Our ref: 26_34337_P

Your ref: H23-1272-25

Site Location: Adj. Carlton Lodge Oxcroft Bank
Shepeau Stow Spalding

Summary of Proposal: Erection of 2
Houses with Garages

J204- PL6

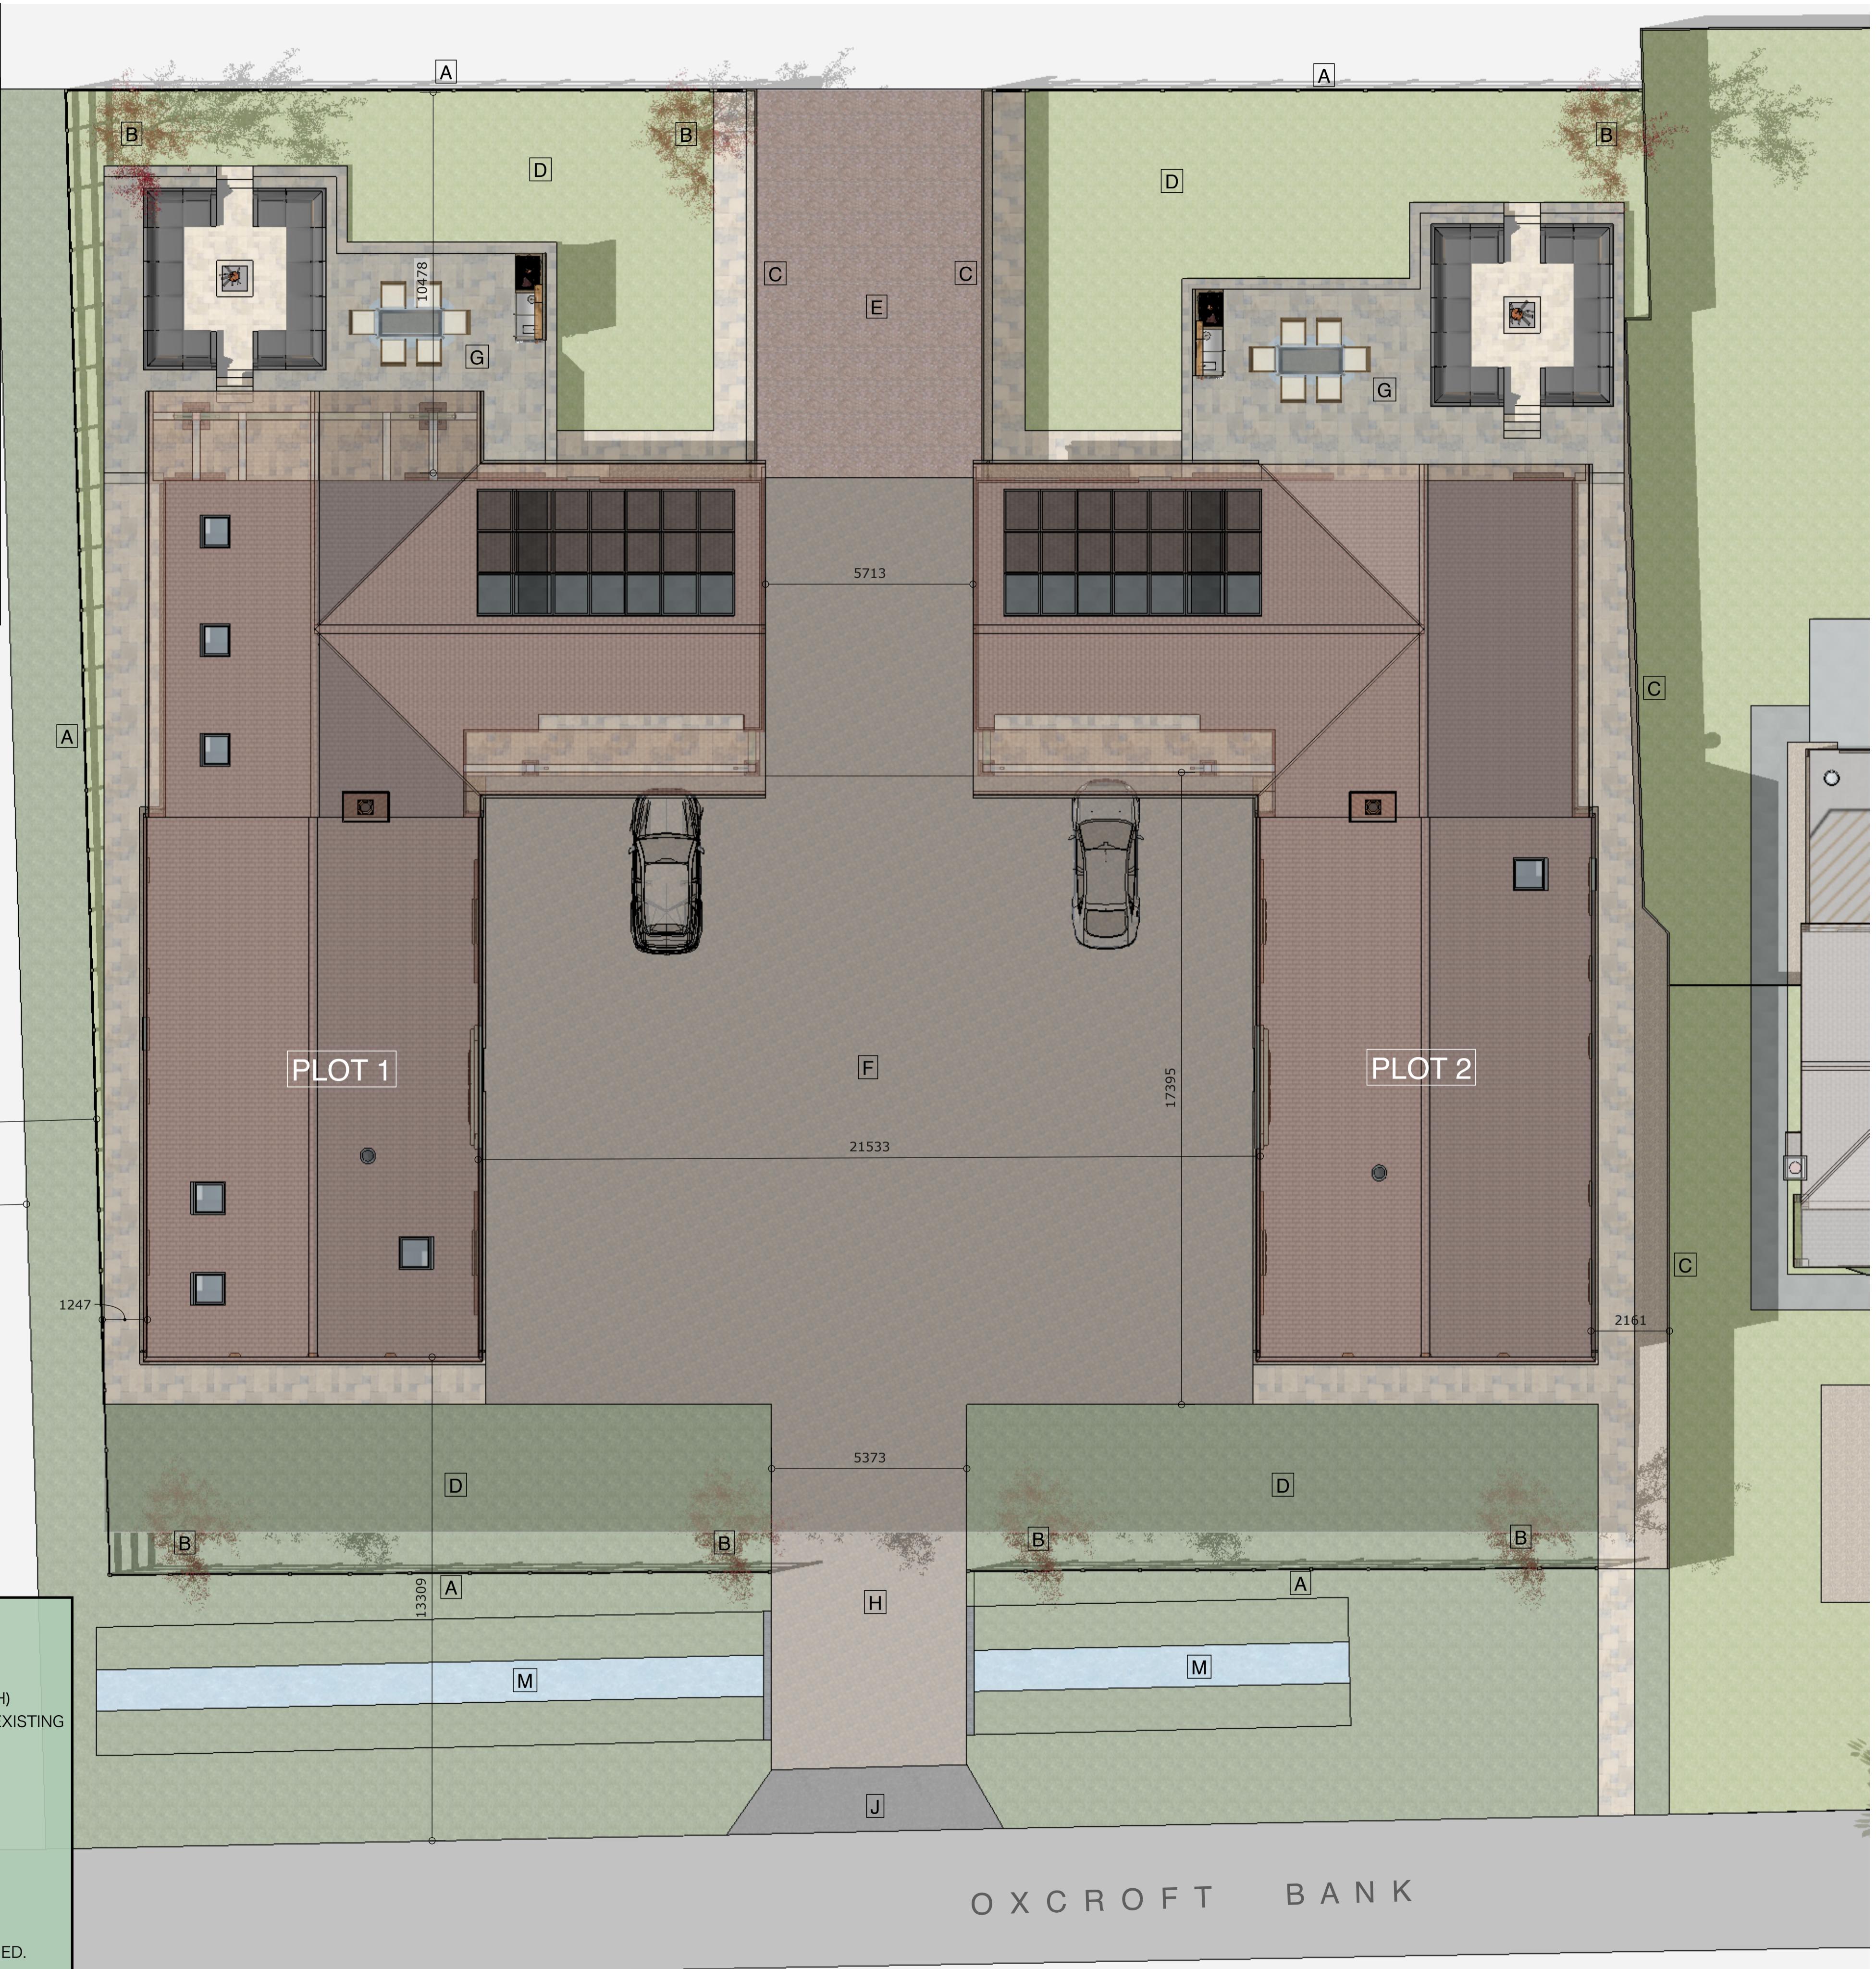
There is an existing track located between the proposed development and the aforementioned Board arterial watercourse. The drawing *Block & Location Plans* (J204-PL6, Julian Warrick, 25/11/2025) within the Flood Risk Assessment (Ellingham Consulting Ltd, Dec 2025), shows that the boundary fencing for the development is located 9m away from the closest brink of the Board arterial watercourse. However, this has not been shown on any other drawings as part of the application.

As such, we assume that no works are currently proposed within 9 metres of the Board arterial watercourse. However, should the applicant's proposals change to include works within 9 metres of the Board arterial watercourse, or if works within 9 metres of the watercourse are proposed at any time in the future, consent would be required under Byelaw 10.
